Honeycutt Hills Community

Lot 02 – Stonefield Model

GARAGE AND PORCH SLABS ON GRADE

M+K Project #: 126-23047 (40/02)

3 TYPICAL GARAGE FOUNDATION
SCALE: 3/8"=1'-0"

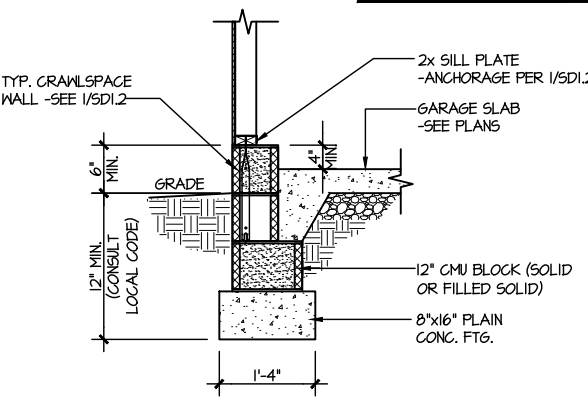
Pursuant to your request, we have prepared this letter to address the garage and porch slabs of the above-referenced lot. It was reported to us, by you, that a 4" slab ledge was not provided as shown in details 3/SD1.2, 5/SD1.2, and 9/SD1.2. It was also reported to us, by you, that in lieu of these 4" slab ledges, the garage and porch slabs are going to be constructed on 95% compacted fill, with 2000 psf allowable bearing pressure, as shown on the structural drawings.

We have analyzed this condition, and it is our professional opinion that this method is structurally adequate, and no repairs are required for the 4" slab ledges not being installed.
